**REQUEST**

Current Zoning: N1-A (neighborhood 1 – A)  
Proposed Zoning: MUDD-O (mixed-use development district, optional)

Approximately 20.12 acres bound by the east side of Old Providence Road and west side of Providence Road, north of River Oaks Lane.

The petition proposes a residential development containing up to 745 dwelling units. The site currently contains two single-family homes but is otherwise vacant and mostly wooded.

SHEET NUMBER: RZ2-00

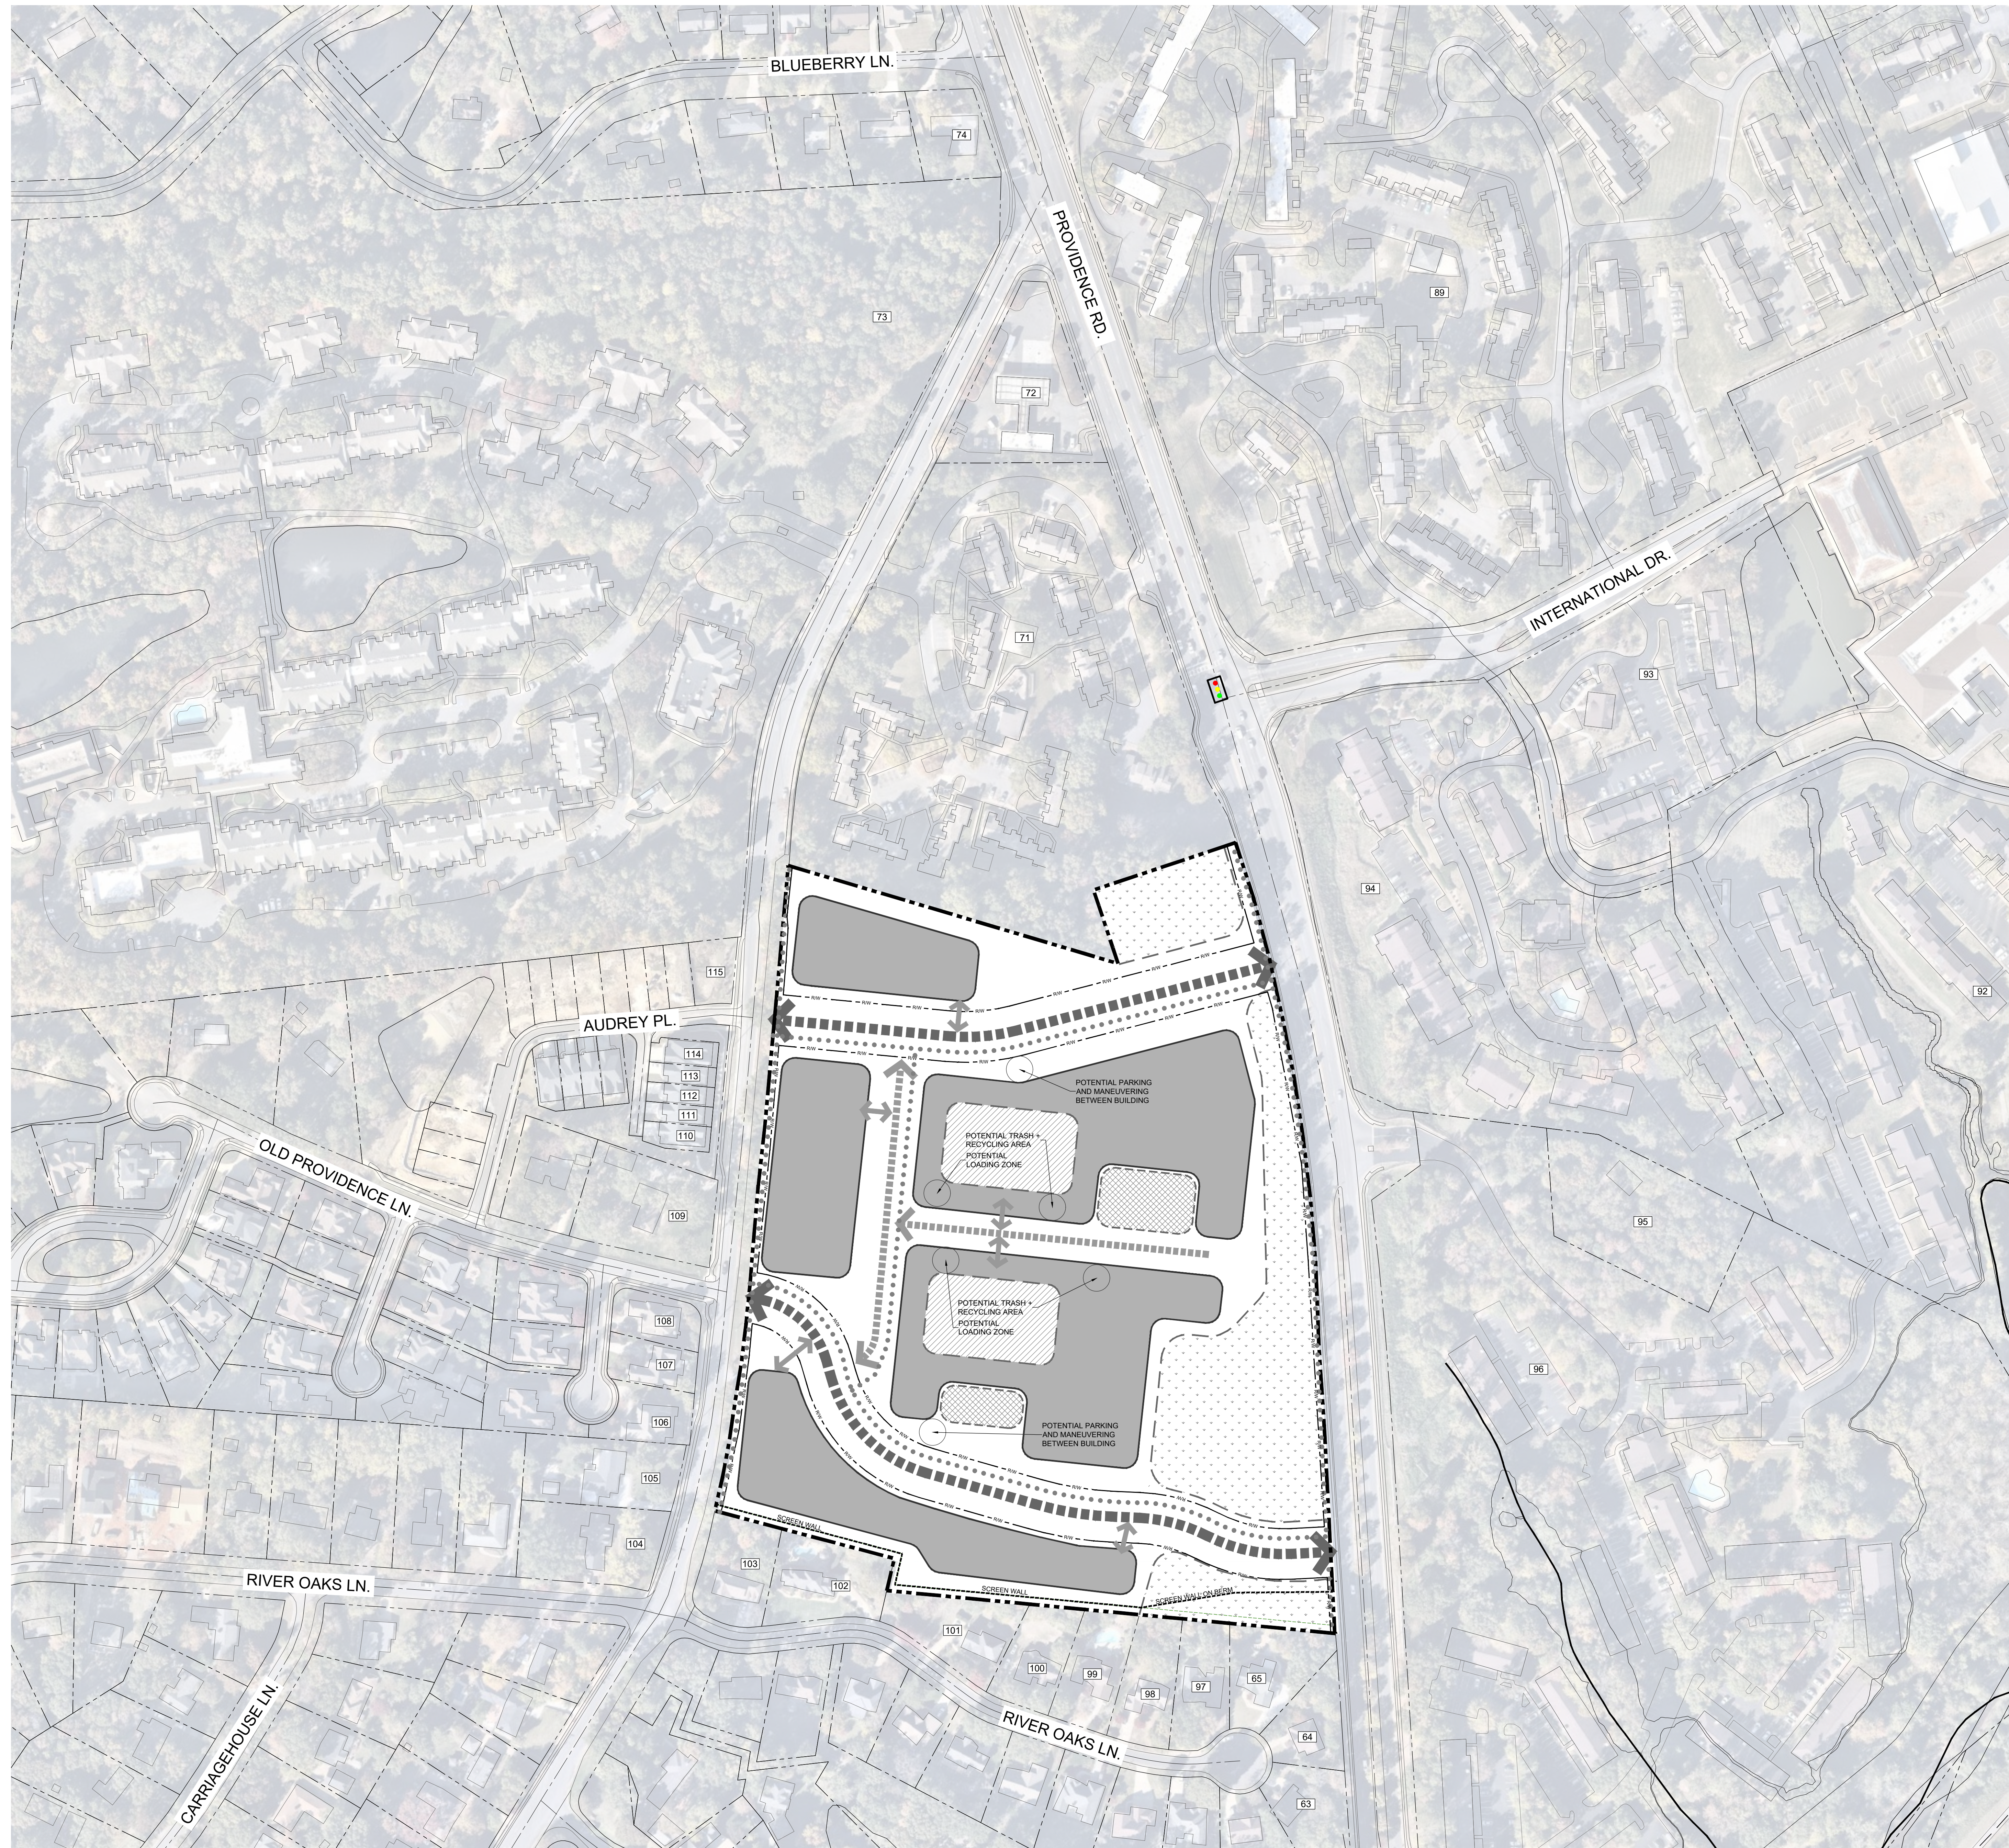
10. CDOT: Fix alignment at intersection between Areas A and C and ensure that there is at least 50' of separation between horizontal curves.
11. CDOT: Please revise Transportation Note i. to specify that all on-site improvements must be completed before the first CO. Coordinate directly with CDOT to identify any phasing of on-site improvements.
12. CDOT: Remove "C" as from General Provision IV.m.4.i(4).
13. CDOT: Change the word below from "will" to "may" in General Provision IV.l.

14. Entitlement Services: An approximate location of the pedestrian connection should be shown on the site plan and coordinated with petition 2023-023.
15. Entitlement Services: Please specify where the proposed 15 detached single-family houses will be located.
